From: Rich Elliott <elliotttr@kvfr.org>
Sent: Thursday, March 19, 2015 2:42 PM
To: Jeff Watson
Cc: Joe Seemiller; Brenda Larsen; Josh Hink; John Sinclair
Subject: RE: Notice of Application - CU-14-00004 McIntosh

KVFR Comments:

EXISTING
OUTDOOR ARENA

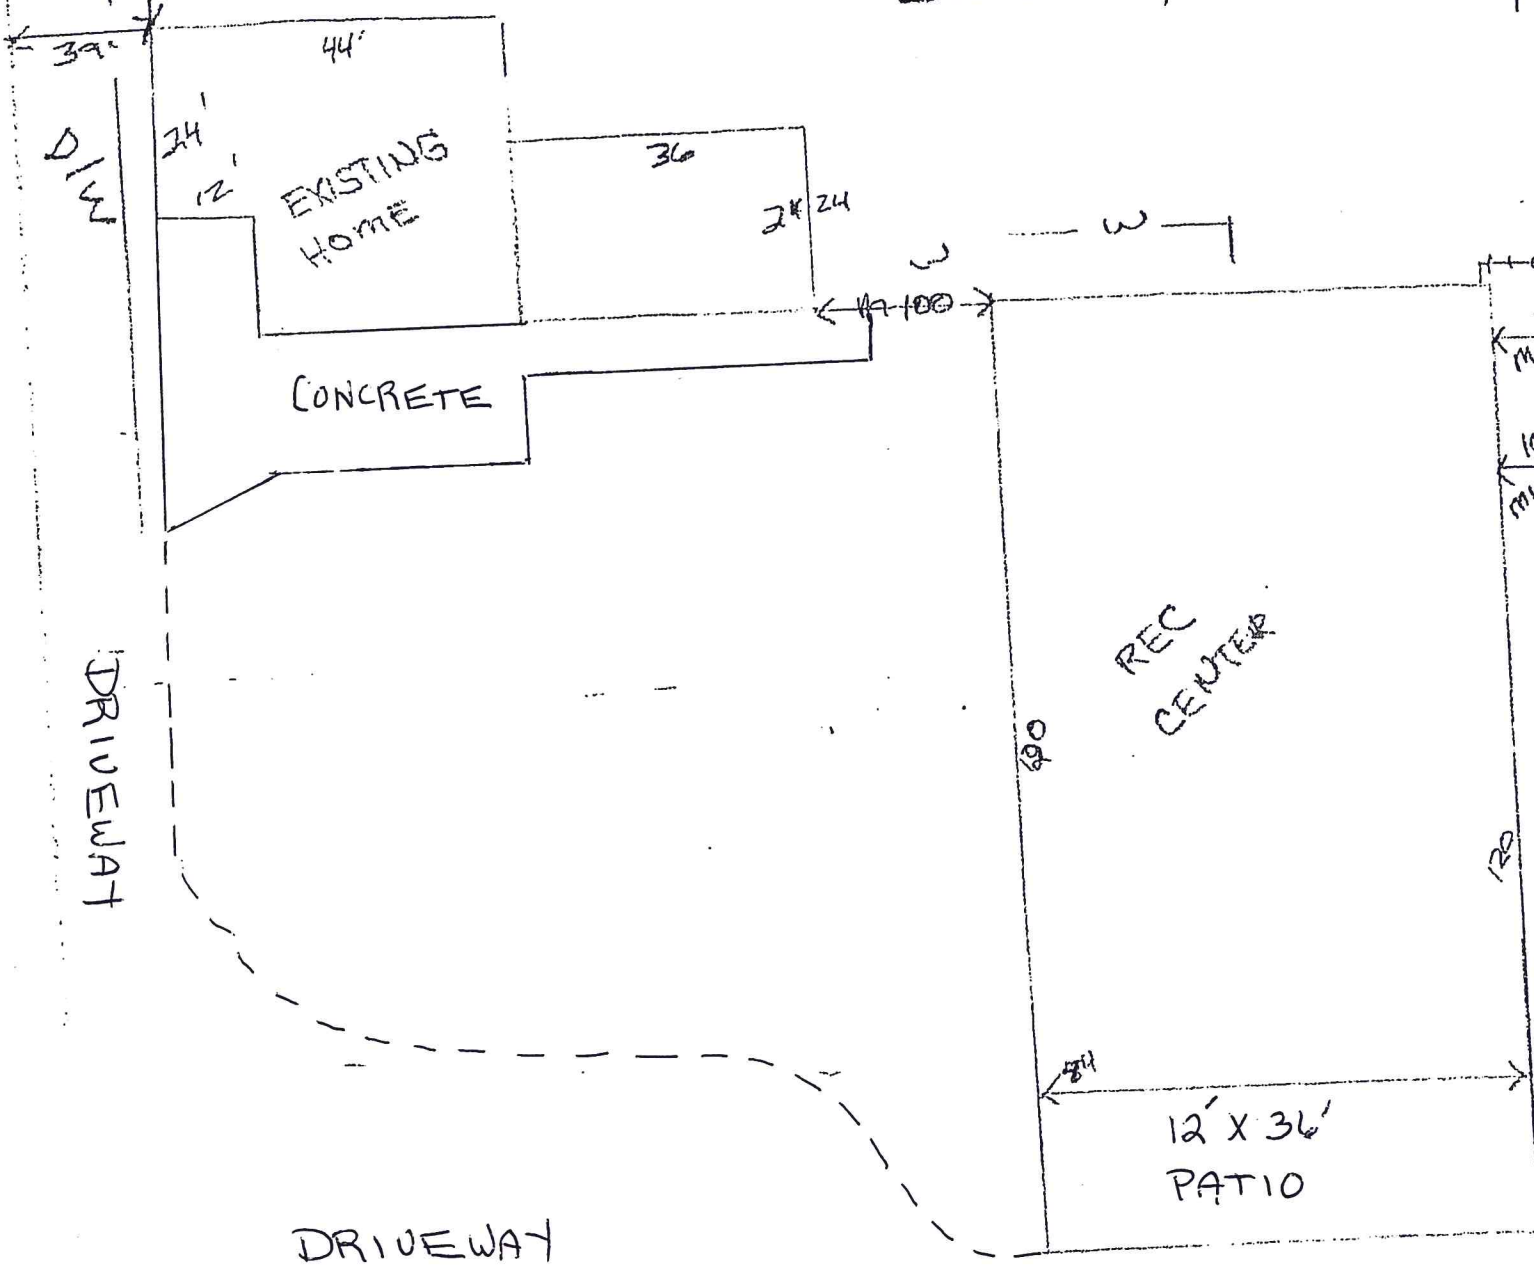
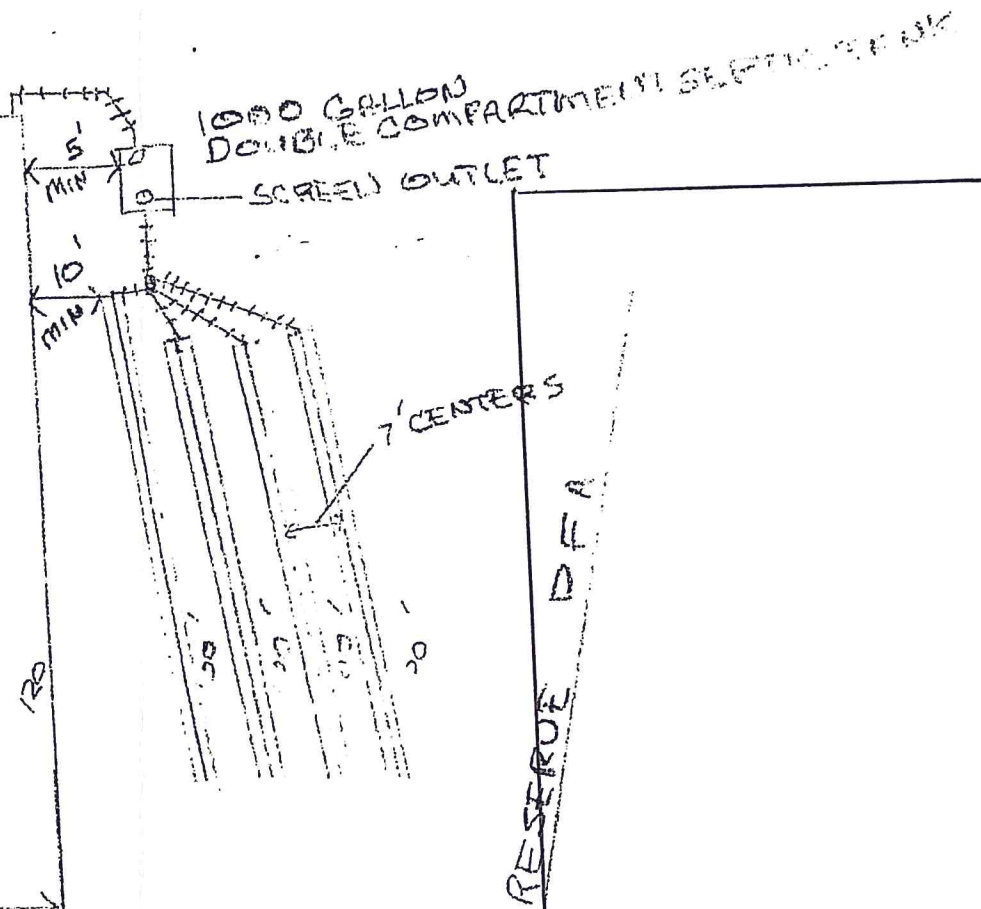
1. Access meeting current IFC Appendix D must be maintained for all portions of the property used as for event purposes. Either fixed parking and access plan or an event specific plan should be required by AHJ and forwarded to KVFR at least 5 days in advance of the event.
2. If the event facilities will involve any fixed facilities, sprinkler and/or alarm systems may be required – AHJ to determine.
3. If the event center will use portable structures (tents), those must meet all applicable codes and are likely subject to permitting requirements.
4. Addressing for the facility must be clearly visible from both directions of travel on the access road.
